From: Joney Ramirez [REDACTED]
Sent: 04 September 2019 15:42
To: Karl Roberts <Karl.Roberts@arun.gov.uk>
Cc: Planning Scanning <Planning.Scanning@arun.gov.uk>; Nick Laister [REDACTED]; nic burrell [REDACTED]
Subject: RE: Planning application A/100/19/PL - Arundel Acre, Angmering

ARUN DISTRICT COUNCIL A/100/19/PL

1711056-SK01

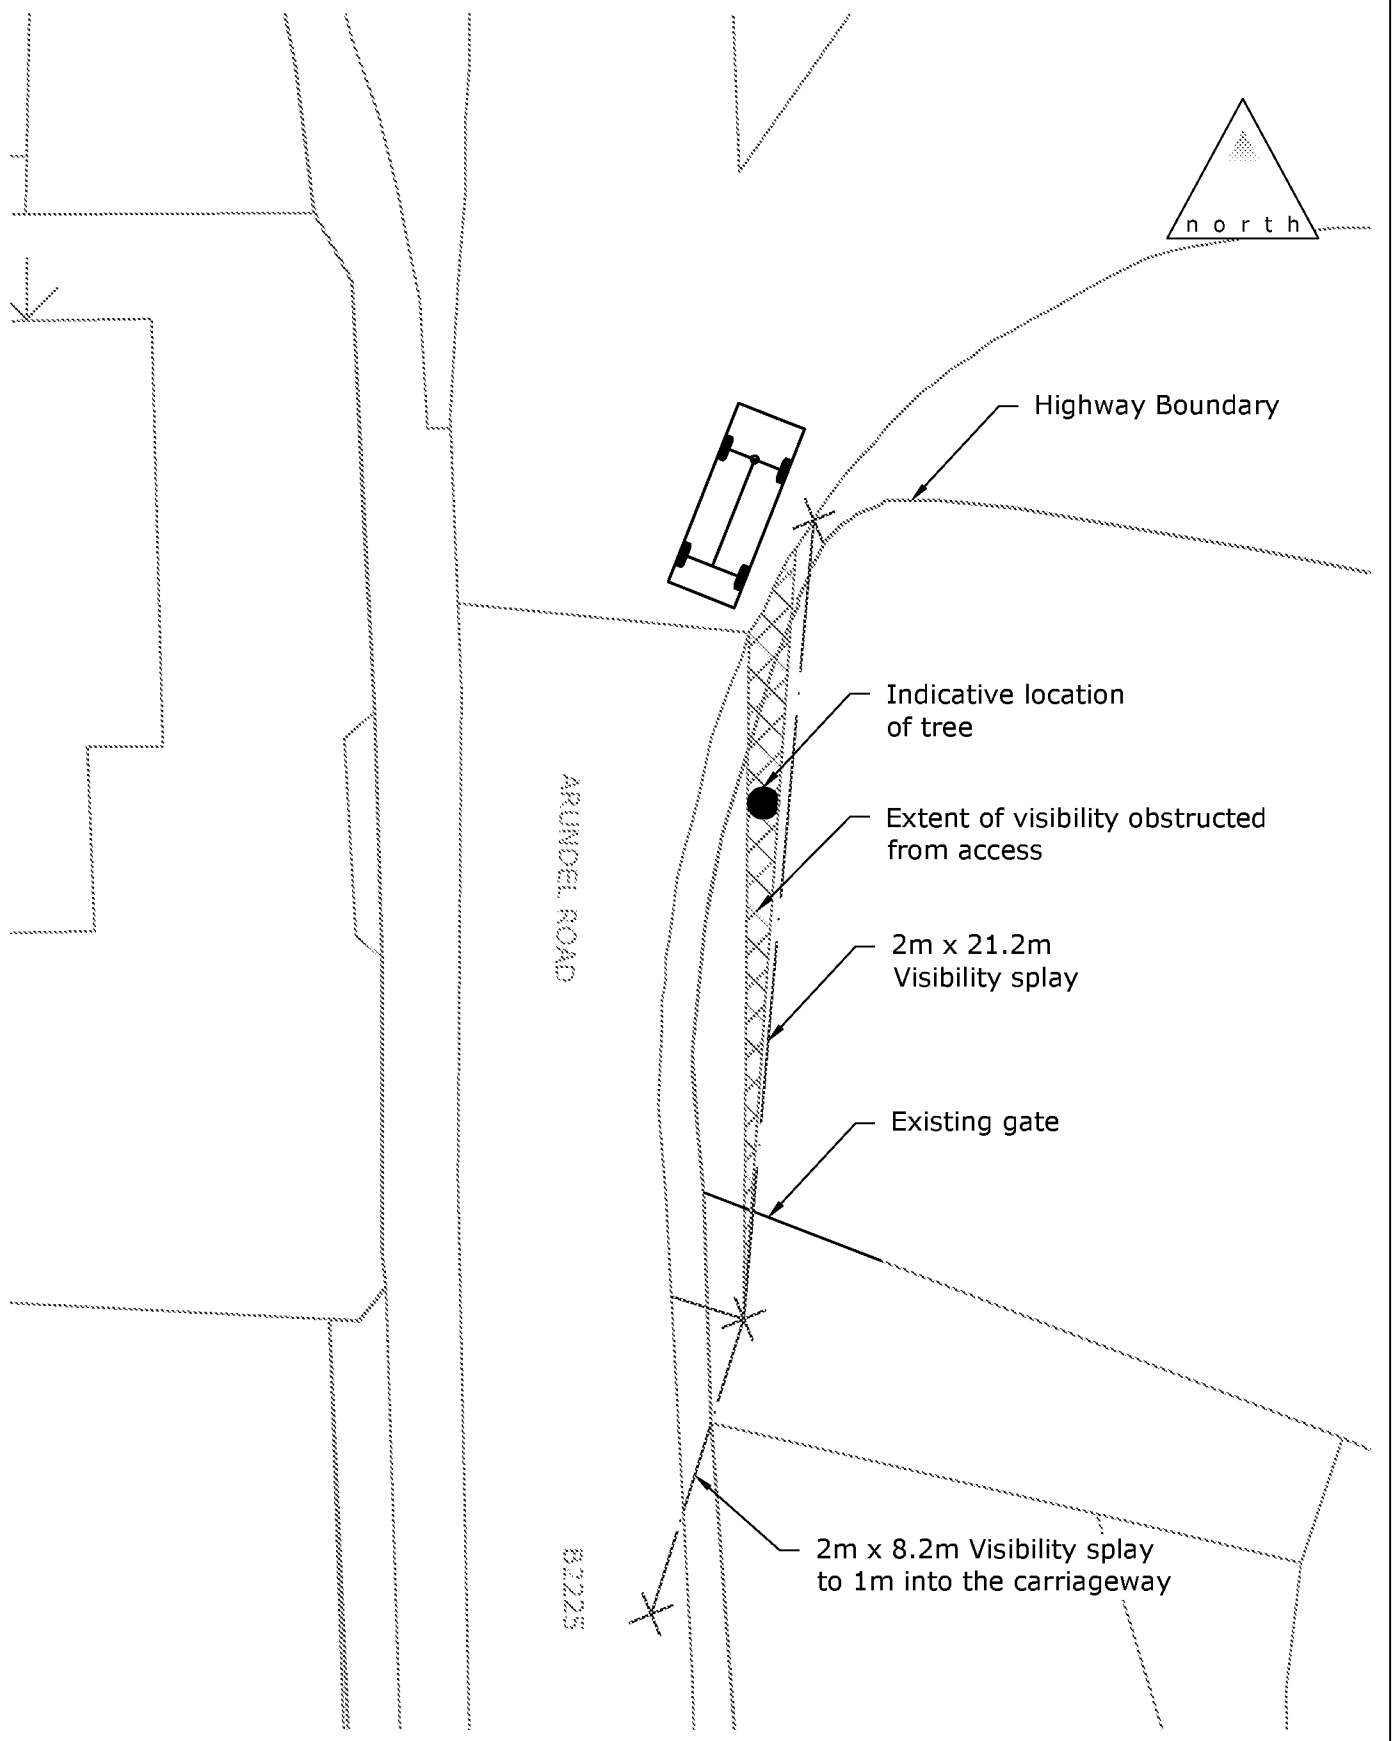
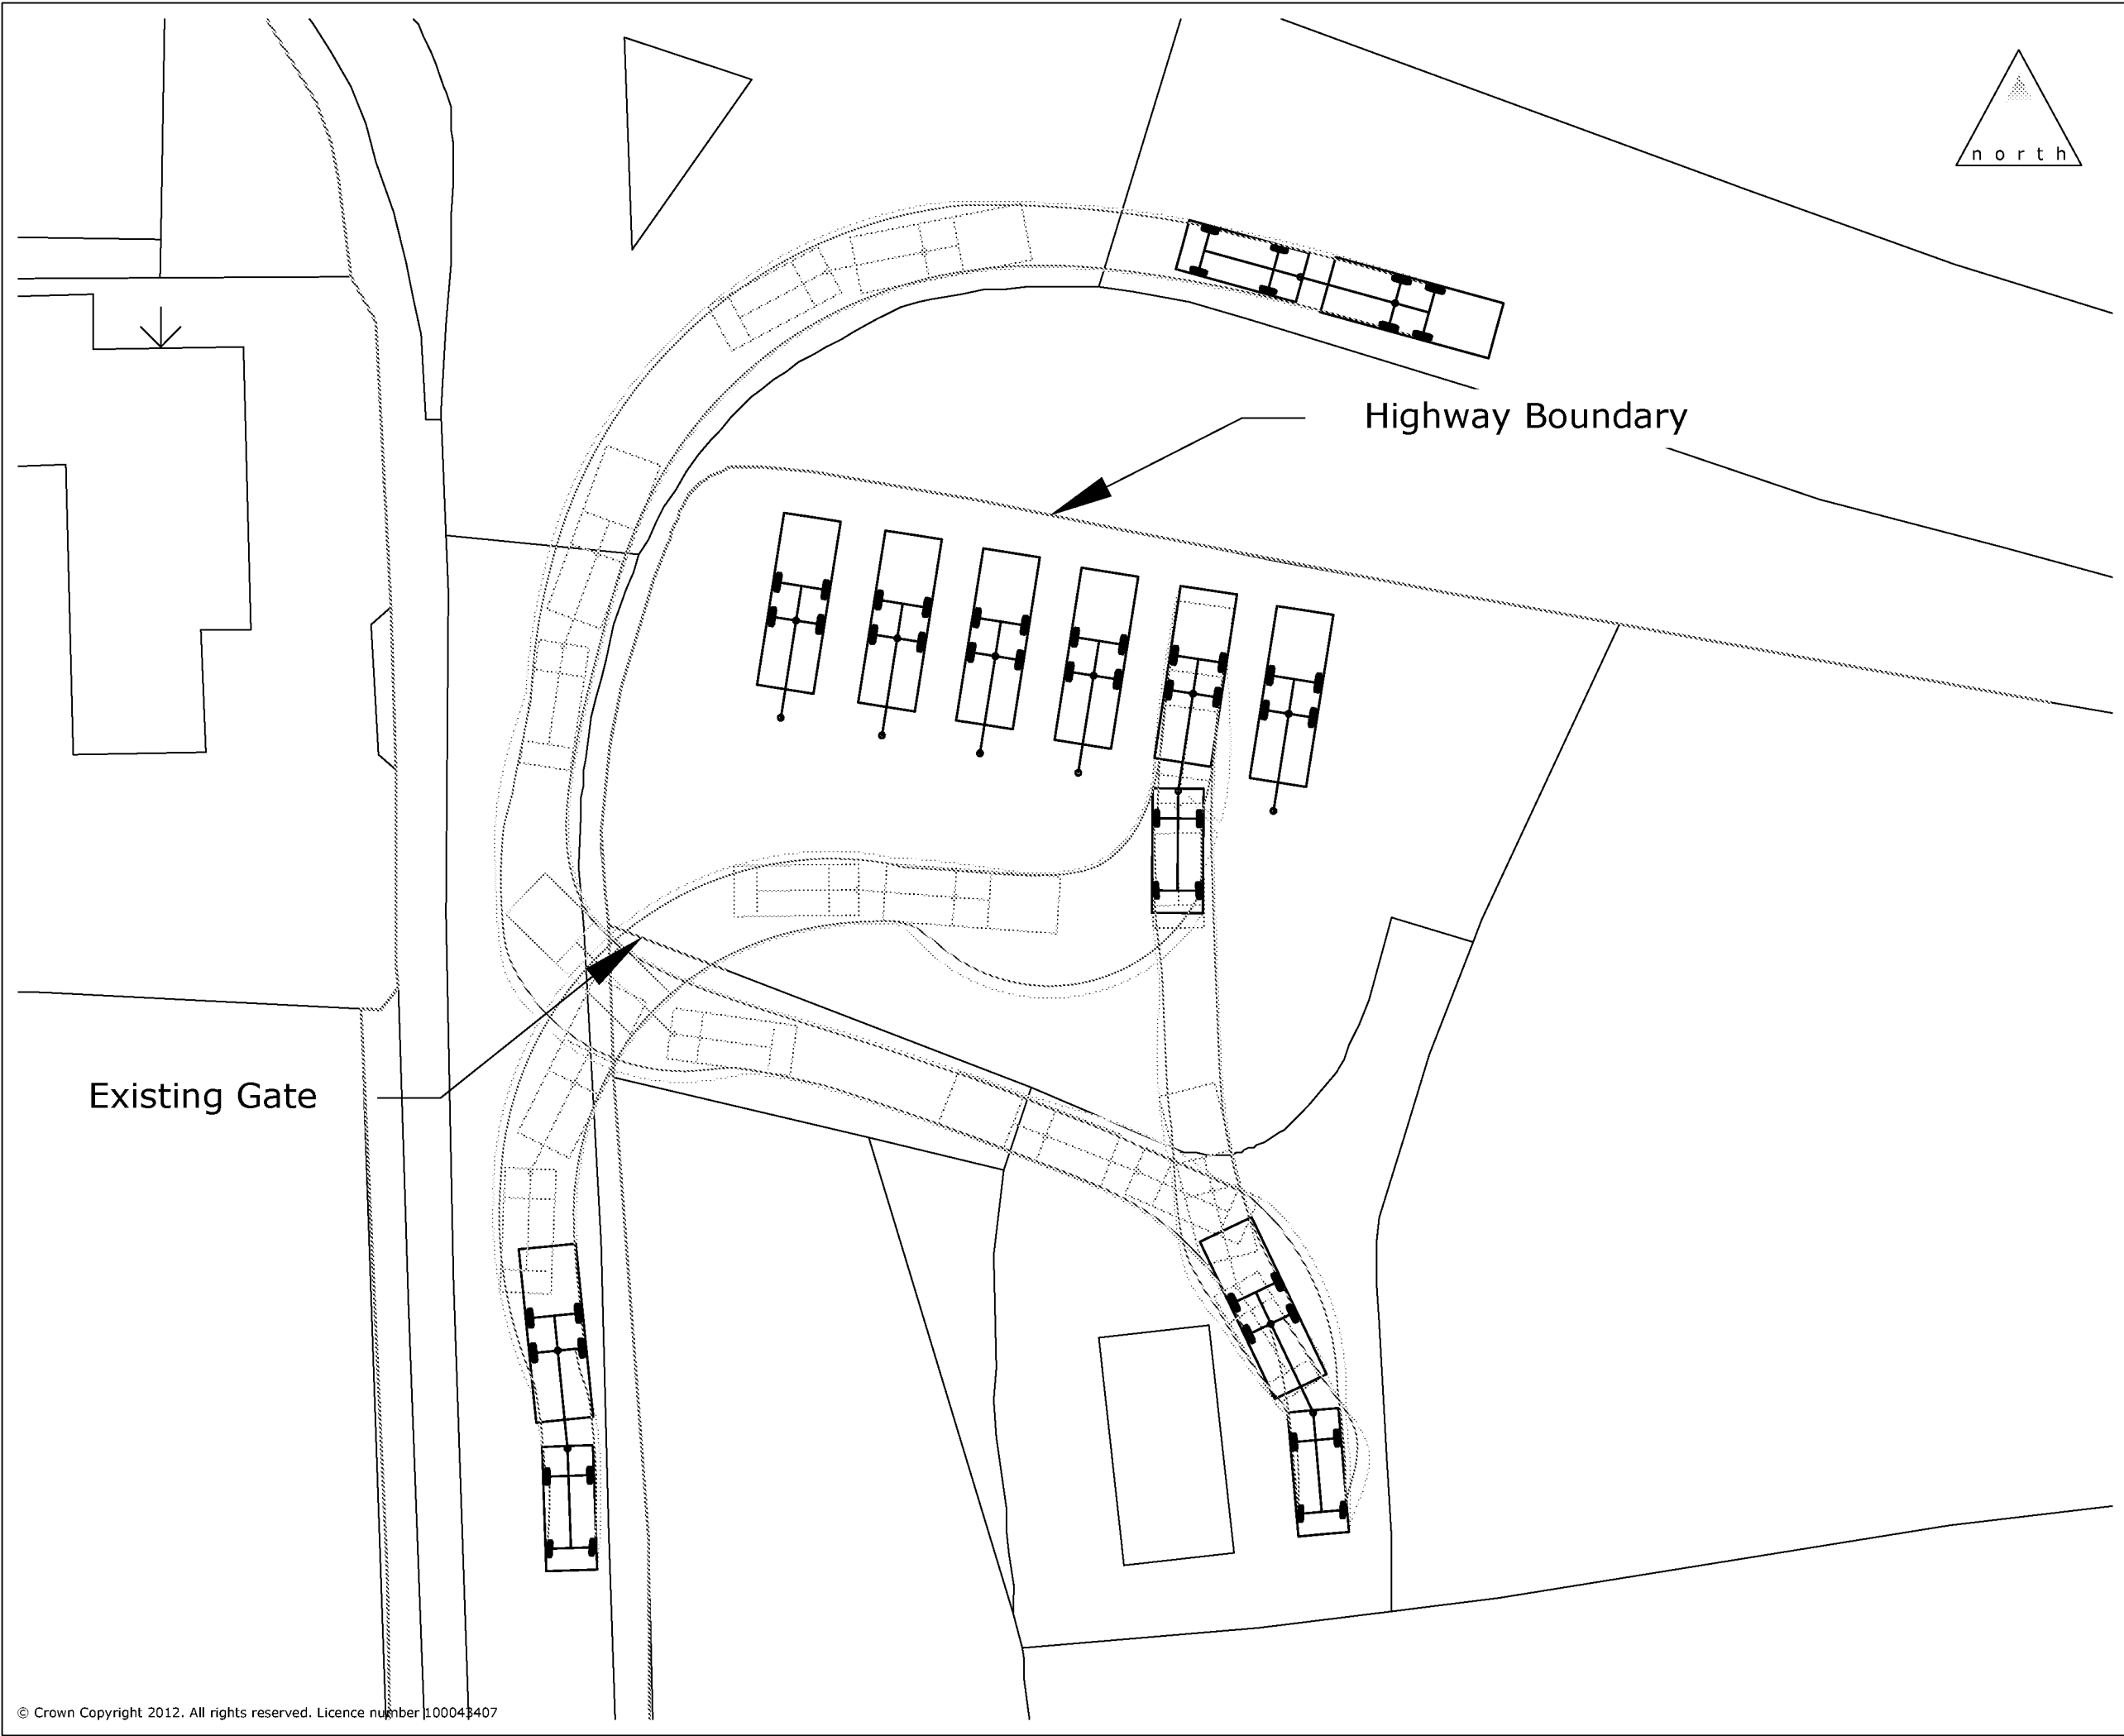
- The applicant will need to provide a plan to demonstrate that the appropriate visibility splays can be achieved to and from the site access and around the corner radius from the westbound A27 into the B2225 Arundel Road to the access in accordance with the minimum Stopping Sight Distance in *DMRB TD9/93 Highway Link Design* and *DMRB TD41/95 Vehicular Access to All Purpose Trunk Roads*. If this is not achievable and

I would be grateful if you could confirm within 7 days if it is your clients intention to provide a plan showing the required visibility splays (notice will also need be served if appropriate). If it is the intention to provide such a plan I would ask that it be submitted within 21 days from the date of this email. Once received we will re-consult Highways England and any other party considered necessary.

Please see attached a copy of Drawing No. 1711056-SK01 Rev. A which forms part of Appendix D of the submitted documentation showing the required visibility splay.
